Application for a non-material amendment following a grant of planning permission.

DEMOLISH SINGLE STOREY BUILDING, EXTENSION &
REFURBISHMENT TO CREATE PRIMARY CARE
RESOURCE CENTRE.

H16 - 0112 - 10

RAISE HEIGHT OF WALL TO REAR OF NEW EXTENSION
AND FOR TROUSING TO ACCOMMODATE NEW LIFT.

C09.105.05

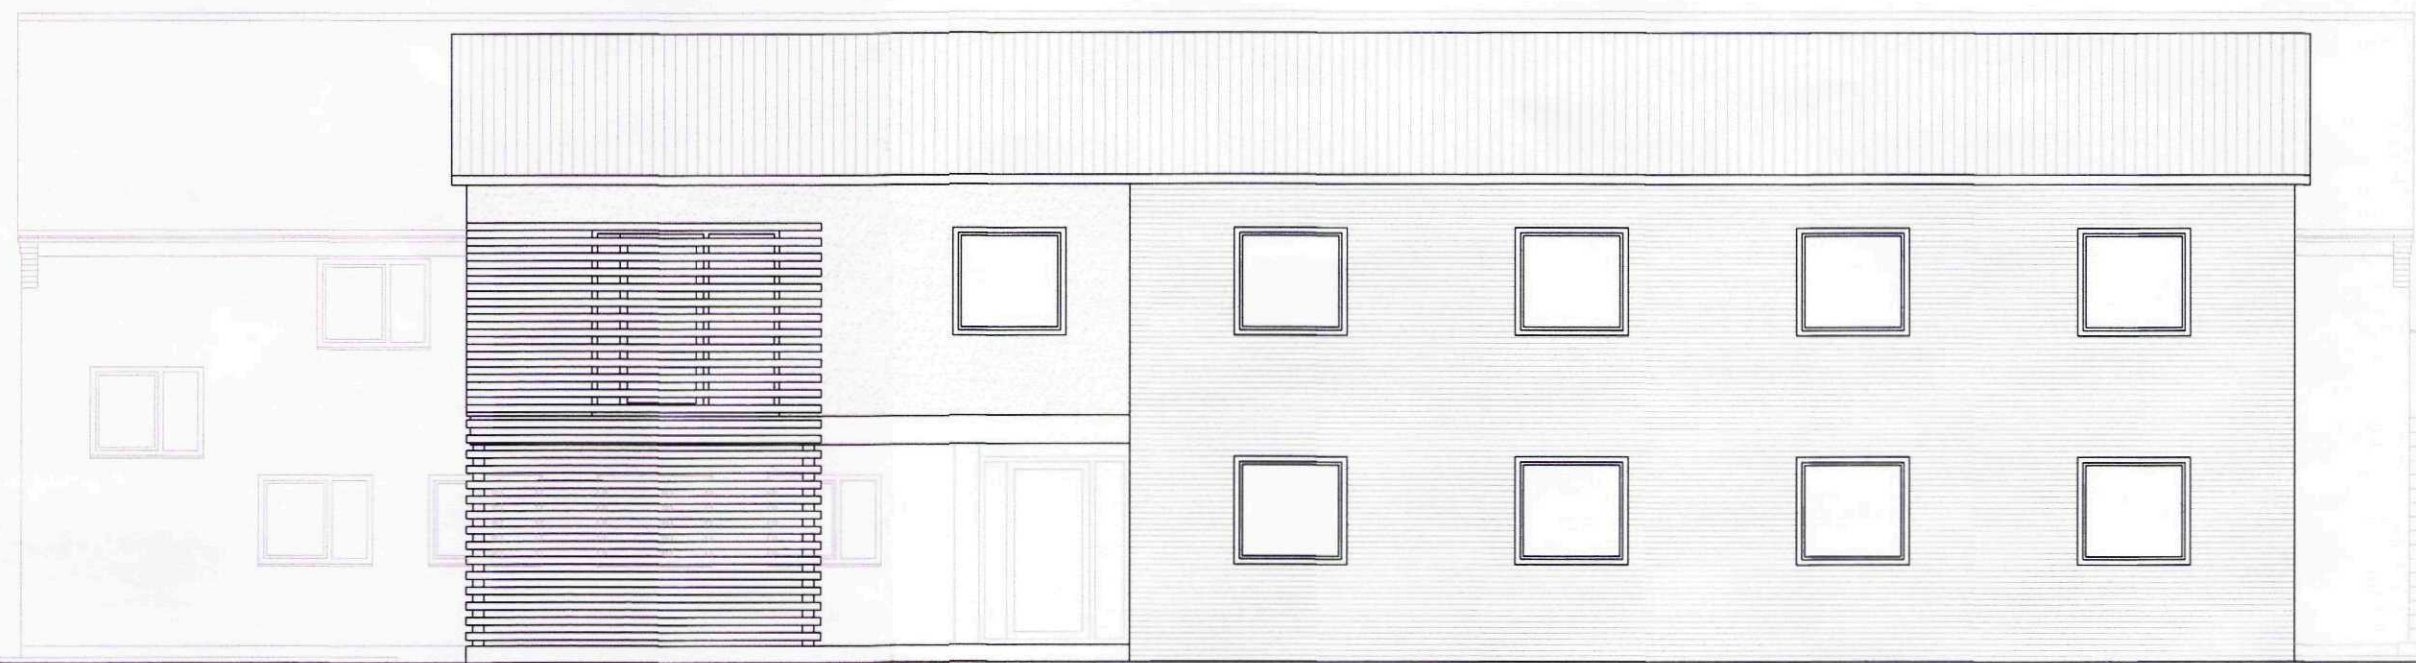
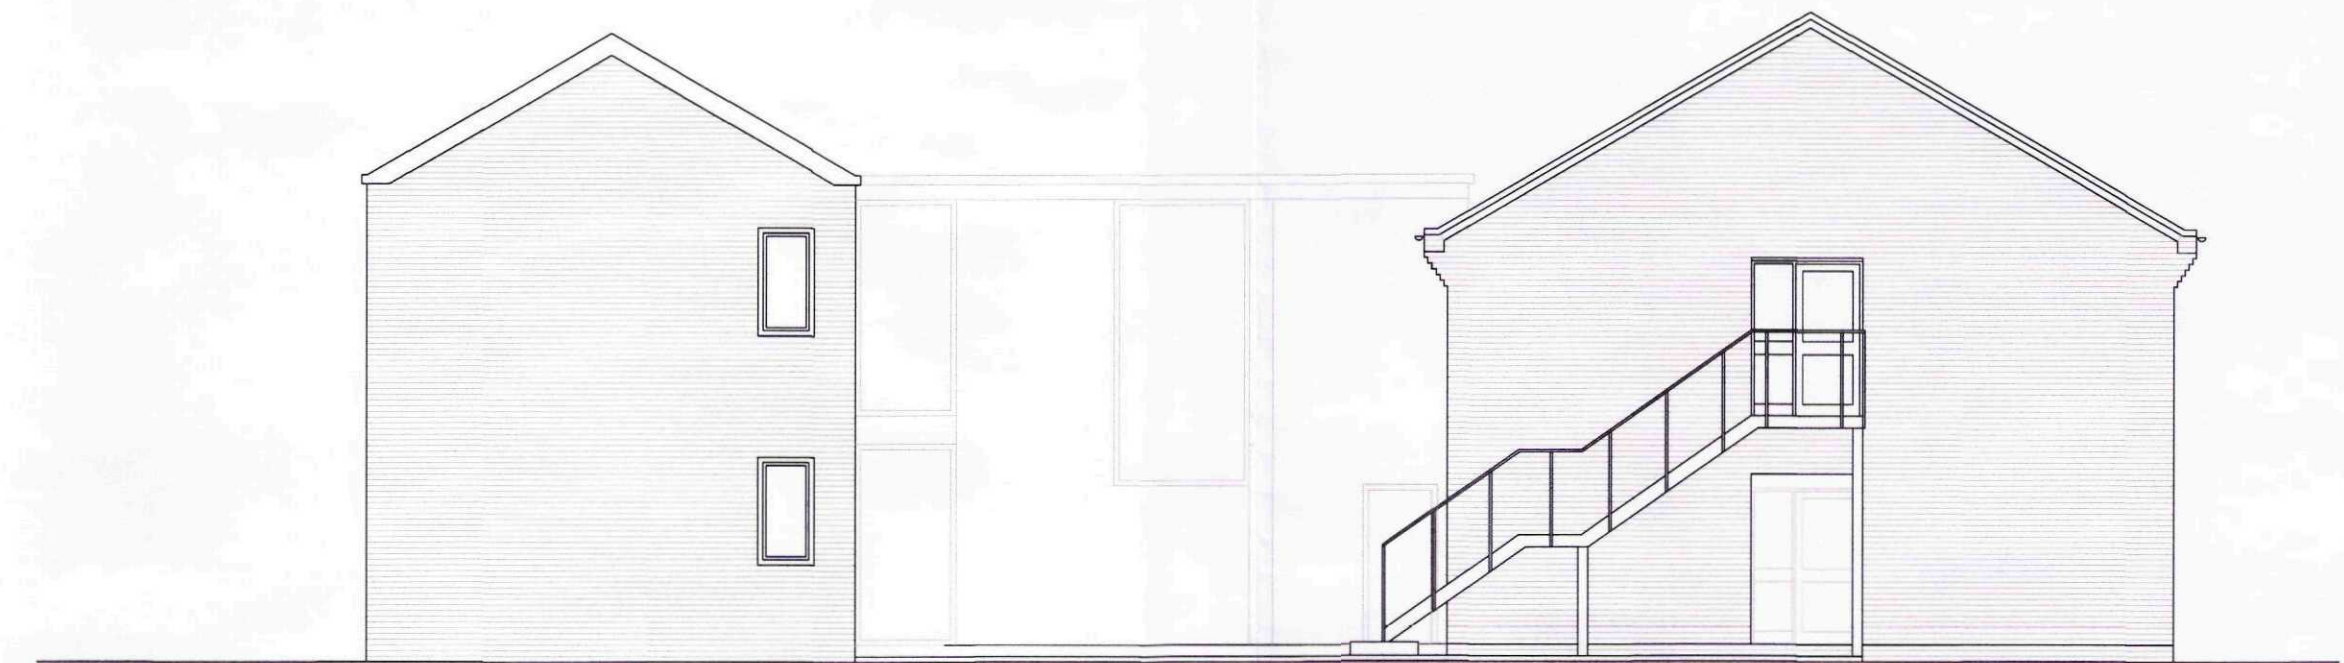
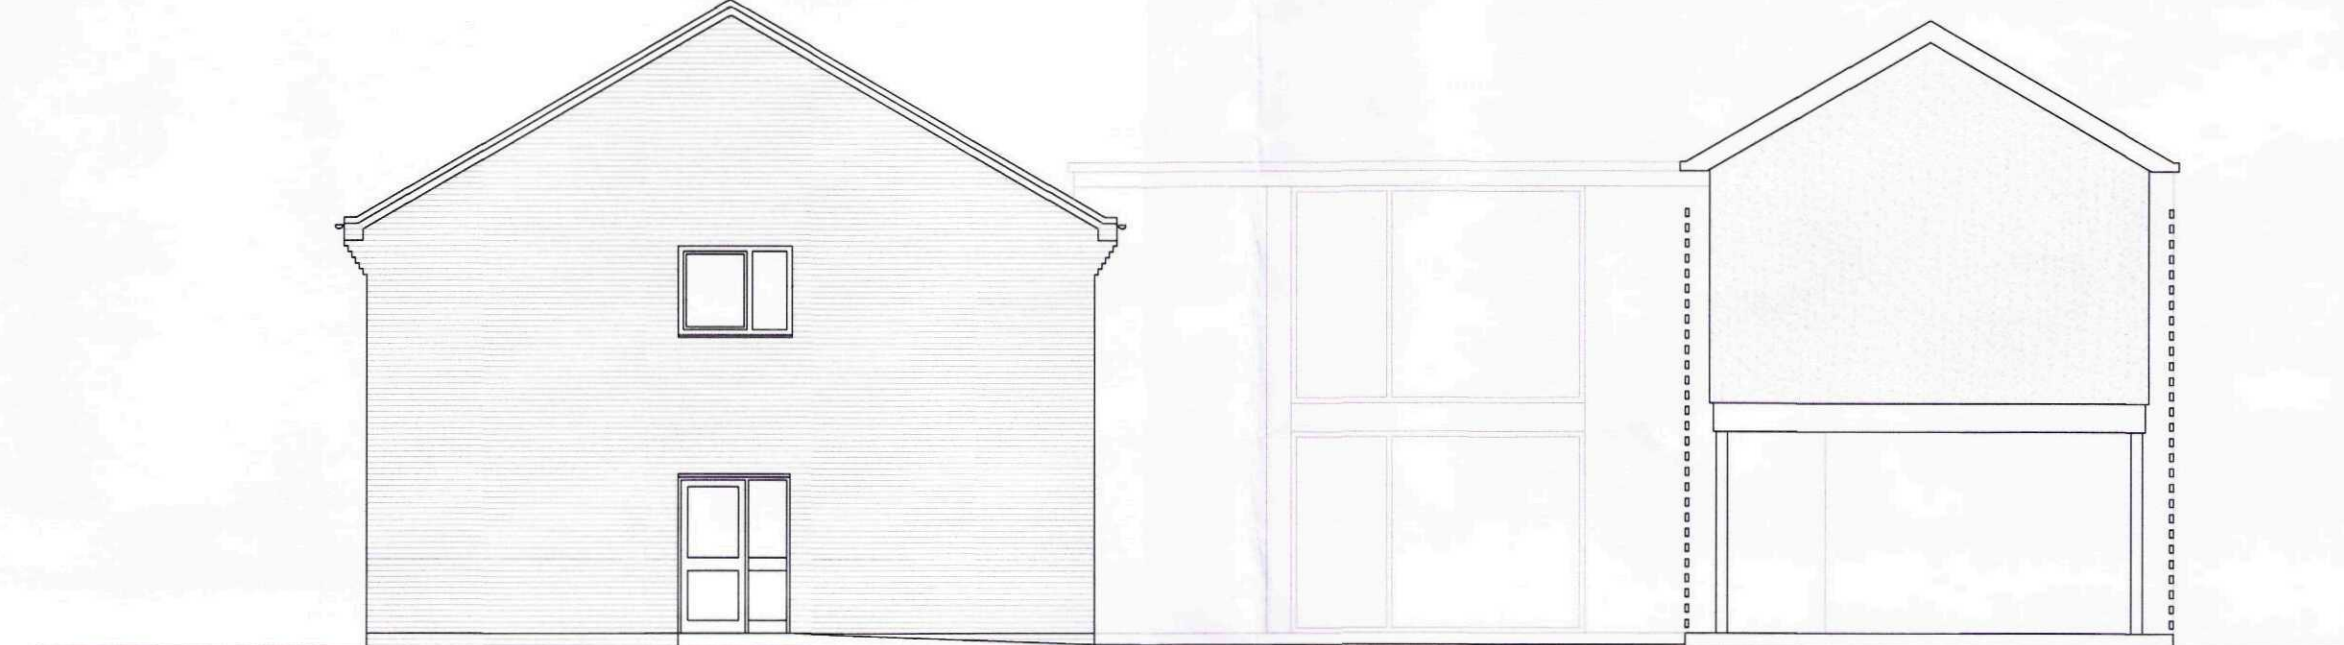
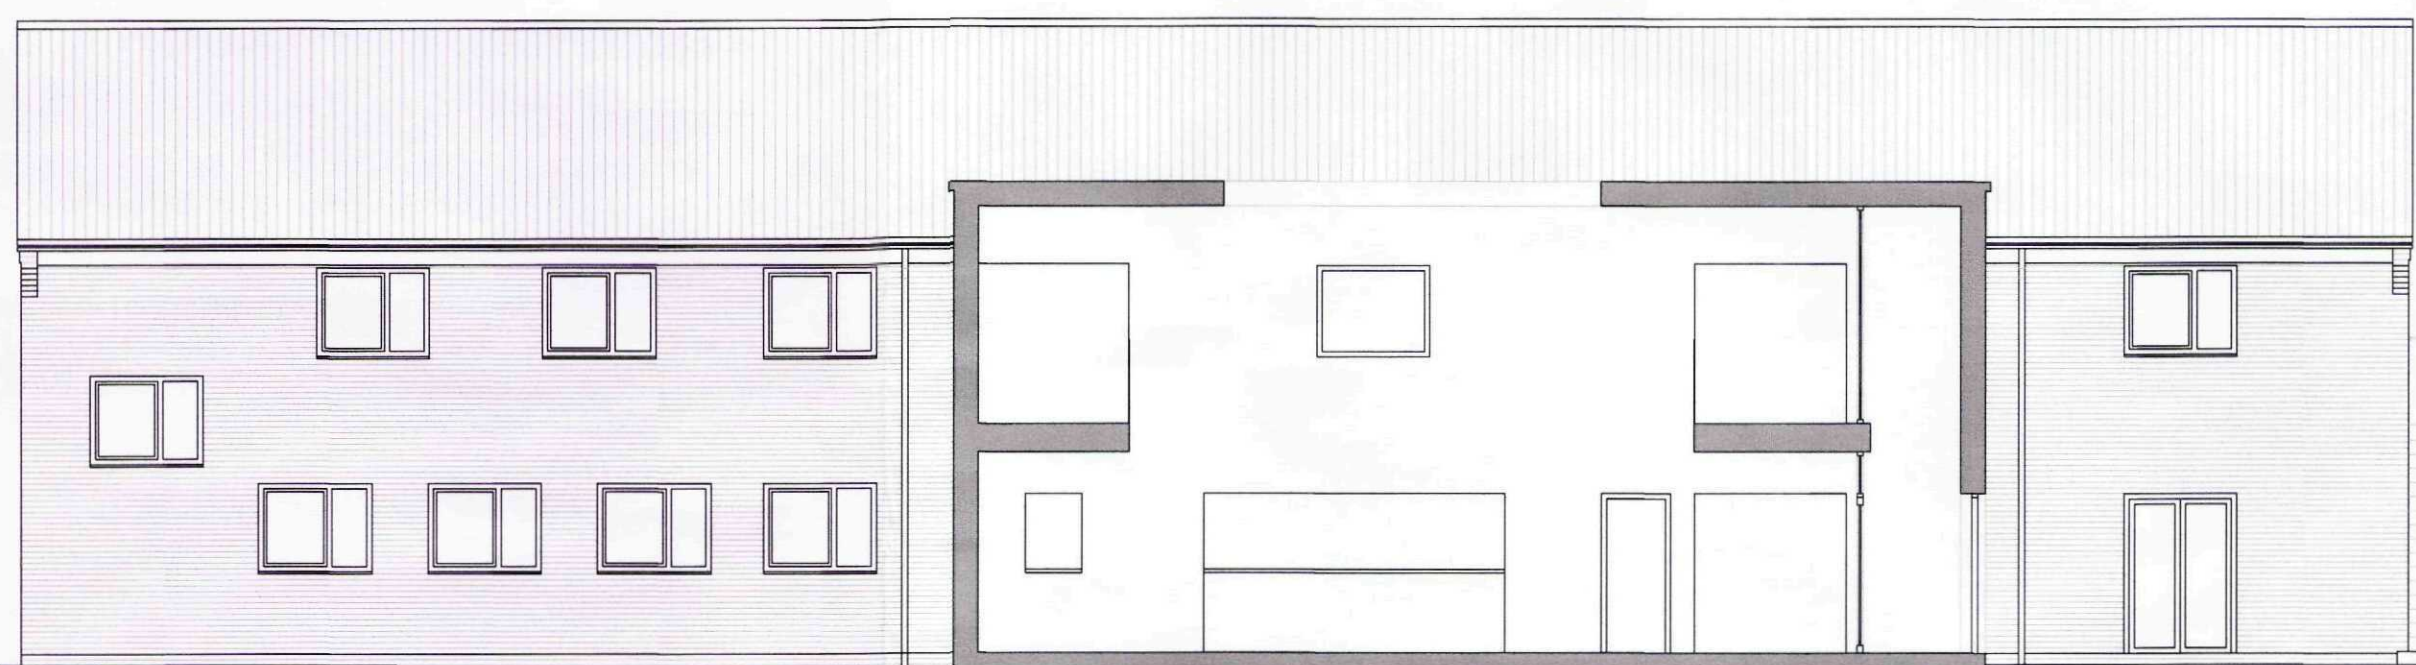
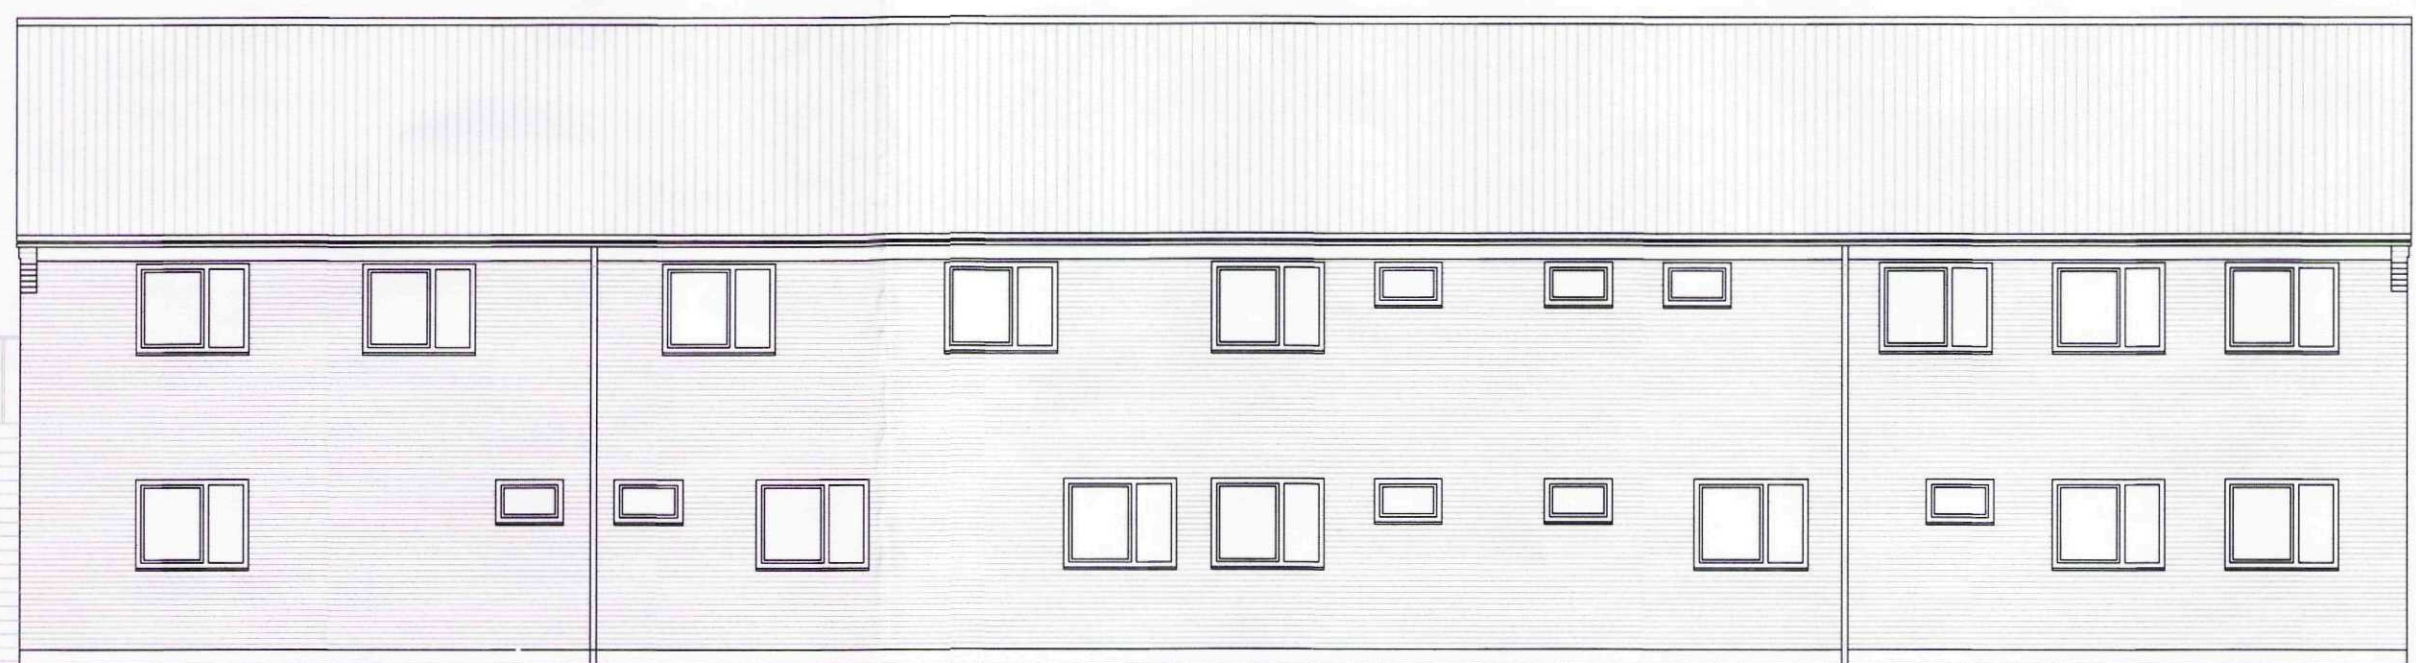
FOLLOWING DETAIL DESIGN TUCKED ROOM FOR NEW LIFT
REQUIRES RAISING.

CO9-105-05B.
